**Planning Act 2008 EN010140**

**Application by Enso Green Holdings D Limited for an Order Granting Development Consent for the Helios Renewable Energy Project**

**Principal Areas of Disagreement between Helios and Burn Gliding Club – 20050600**

**7 January 2025**

## **Environmental Statement Figure 15.1: Cumulative Schemes Plan**

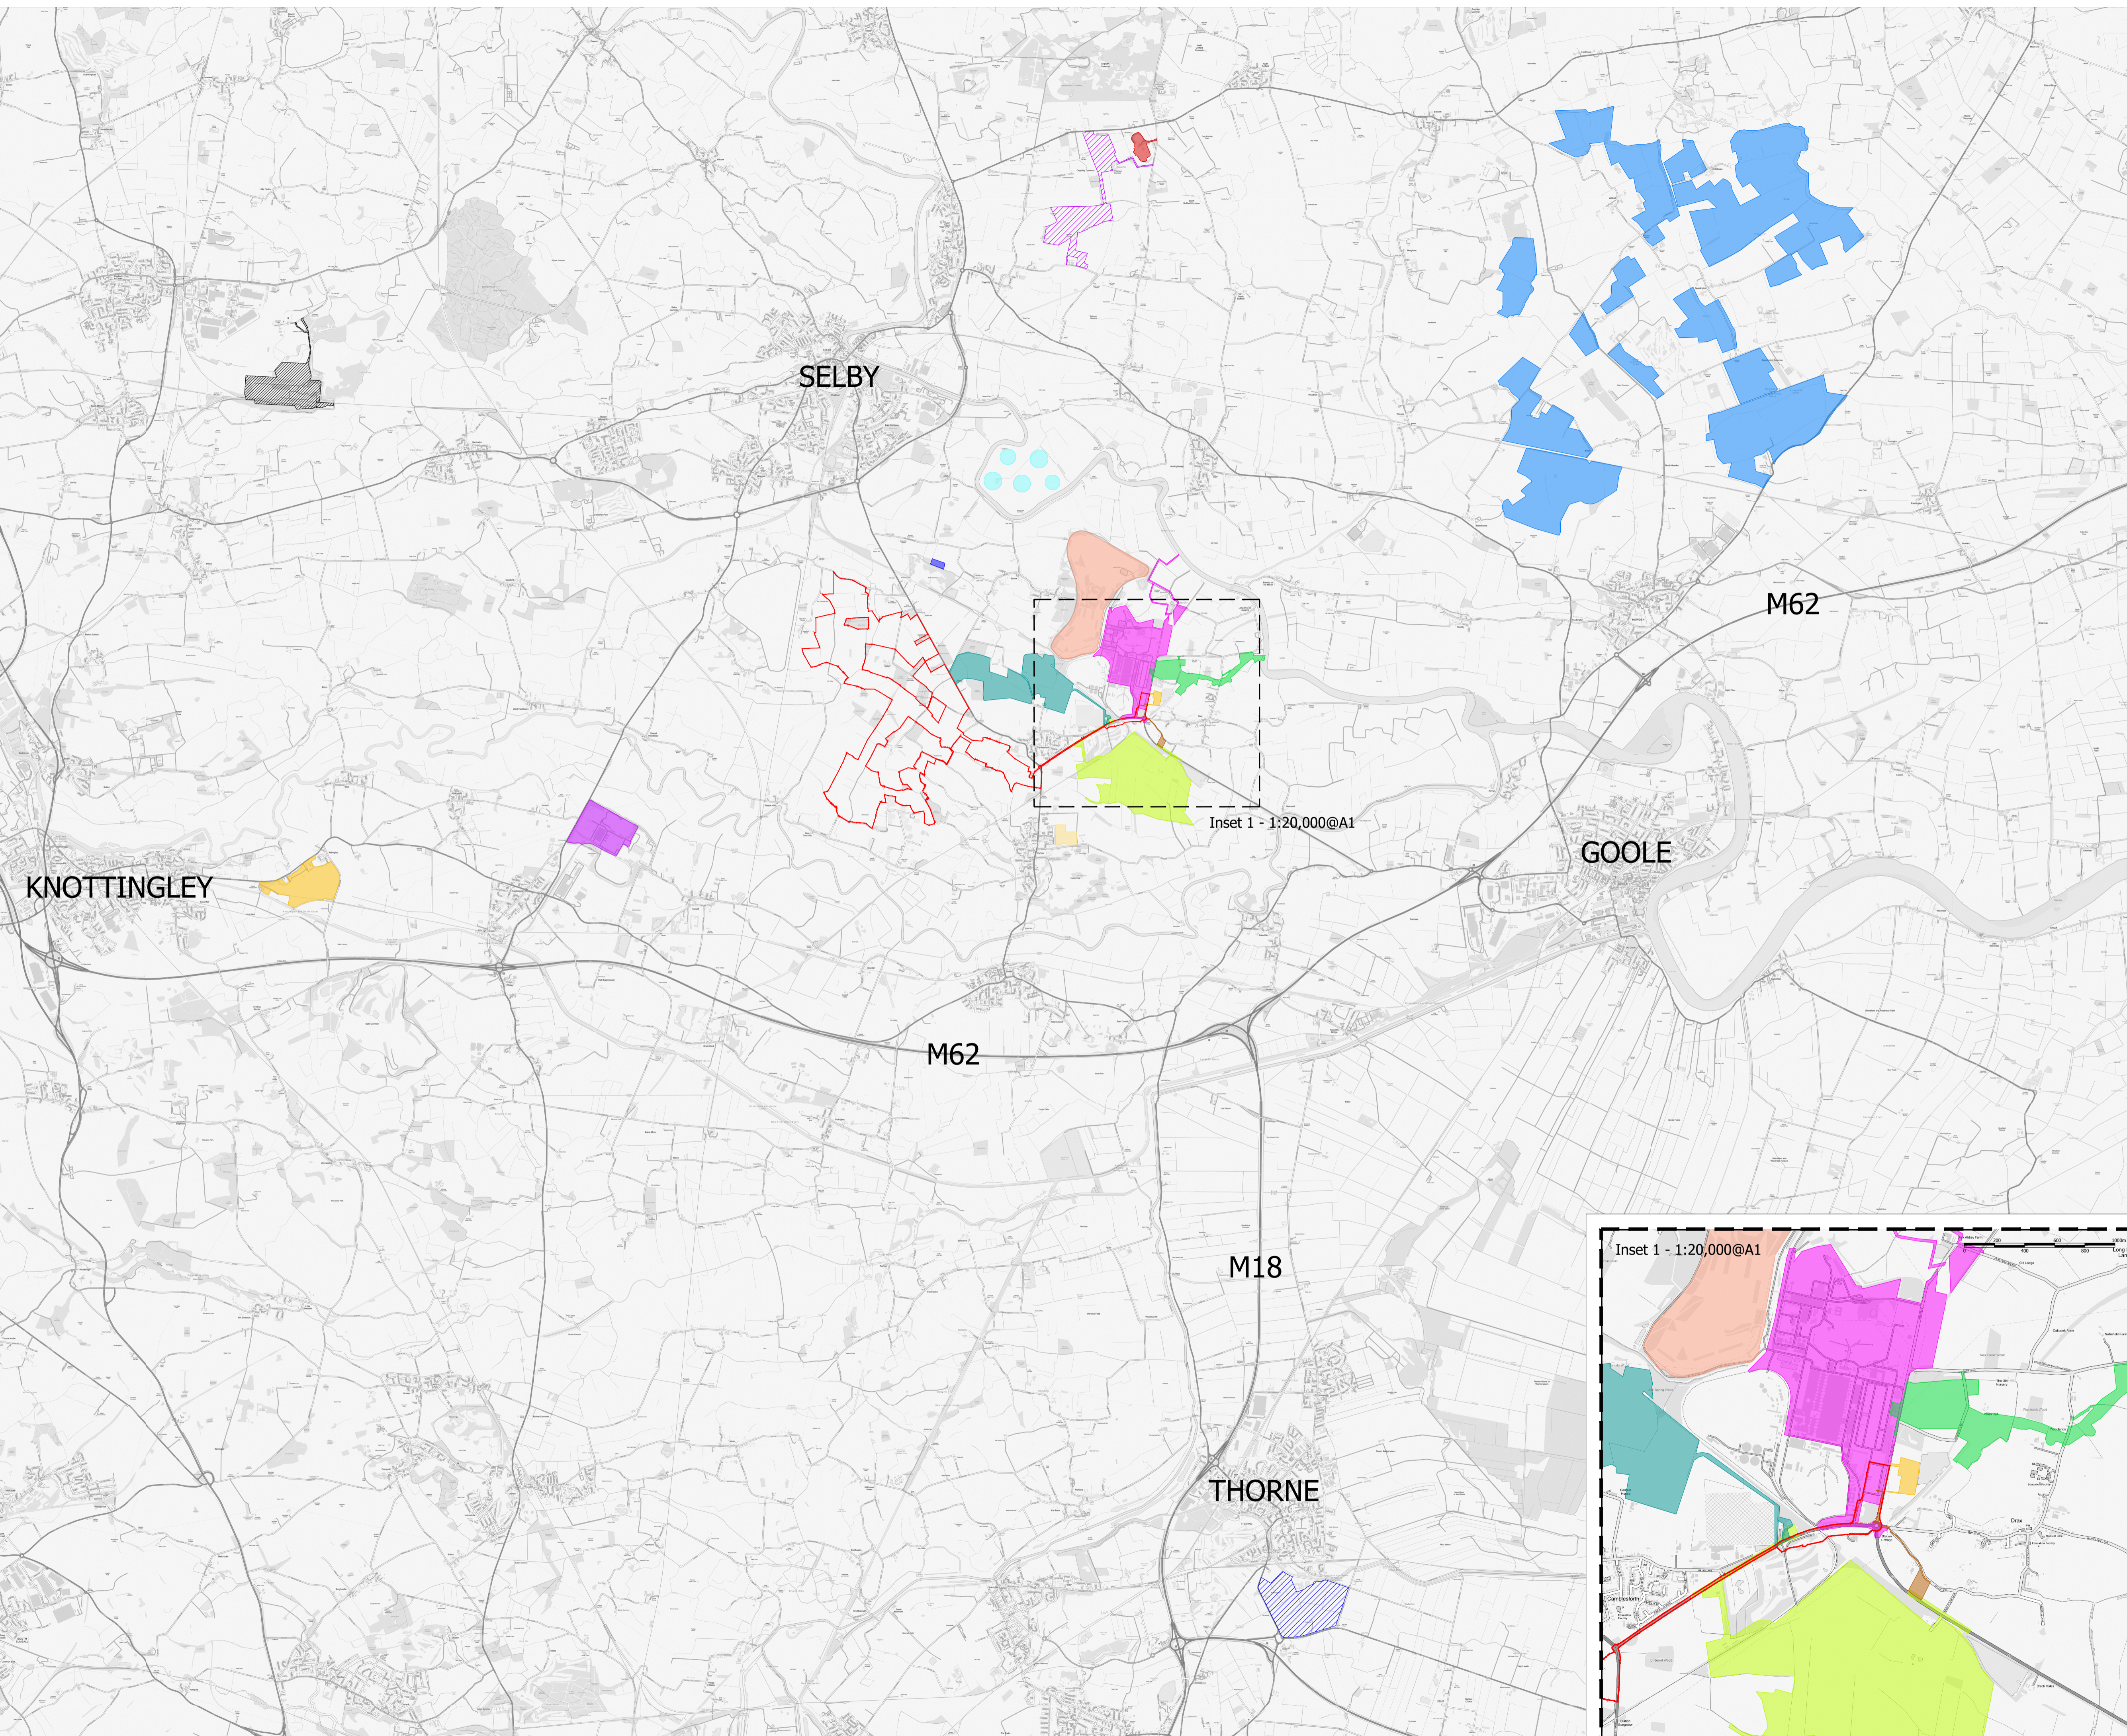
<p><b><i>Cumulative Impact</i></b></p>			
<p>The Applicant has not considered the potential cumulative impact of the safety issues raised by glint and glare, EFATO and thermal updrafts.</p>	<p>BGC considers that none of the three key safety issues addressed above has not been fully addressed – essentially as the nature of gliding activity has not been understood. BGC has now provided a significant level of technical detail to the Applicant.</p>	<p>In addition to proper evaluation of each of the key safety risks, the Applicant should address the cumulative impact.</p>	<p>Potentially possible if additional work is commissioned by Helios and there is further engagement and discussion with BGC.</p>

Furthermore, the cumulative impact on aviation safety has not been addressed, contrary to the provisions of the Air Navigation Order and Aviation and Planning Policy.		
--	--	--	--
